## Building Inspections - Fwd: 100 Deerfield Rd: Change of Use Application & Building Layout Clarifications

**From:** Ann Machado  
**To:** Building Inspections  
**Date:** 3/9/2015 10:31 AM  
**Subject:** Fwd: 100 Deerfield Rd: Change of Use Application & Building Layout Clarifications  
**Attachments:** 100 DFR Use Permit Electronic Signature.pdf; 100 DFR Use Permit - Sketch on file.pdf; 100 DFR Use Permit - Updated Sketch.pdf; 100 DFR Use Permit Application.pdf

Please note that the Updated Building Sketch corrects the following incorrectly identified items on Building Sketch currently on file.

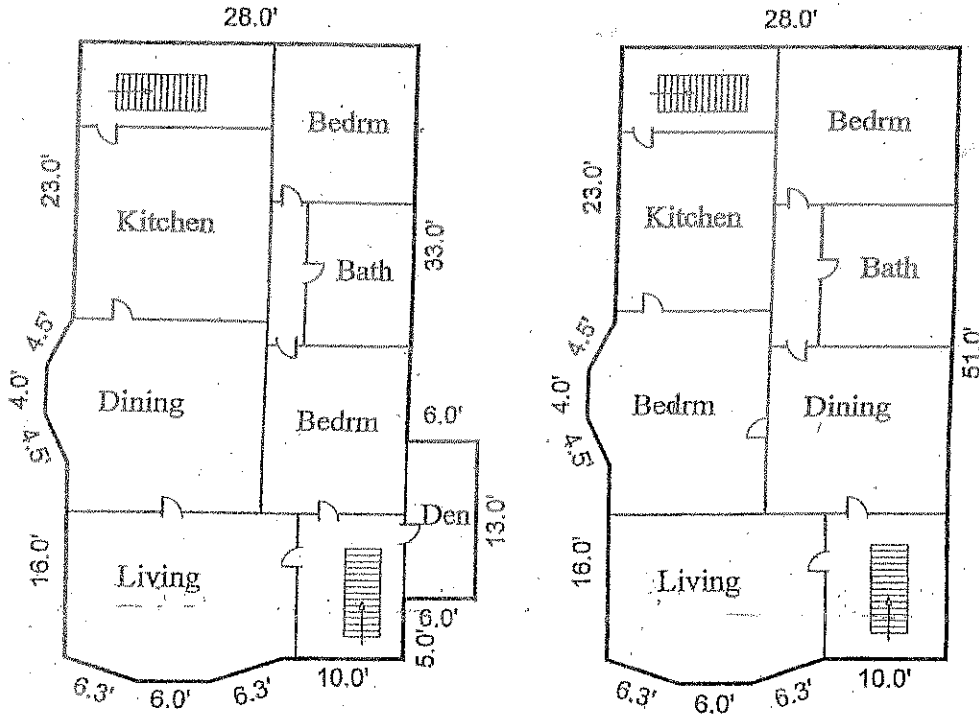
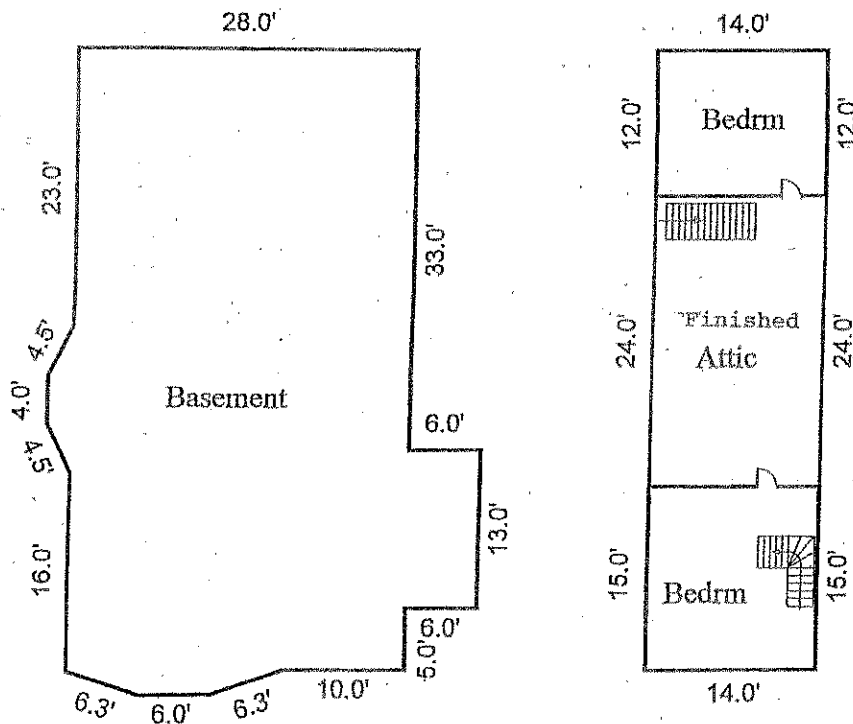
- 1) 1<sup>st</sup> Floor: Entry area doorway and stairwell representation
- 2) 2<sup>nd</sup> Floor: Bedroom & Dining room corrected locations, stairwell representations
- 3) 3<sup>rd</sup> Floor: "Finished Attic" actual layout as originally completed, correct location of stairwell for second means of egress.
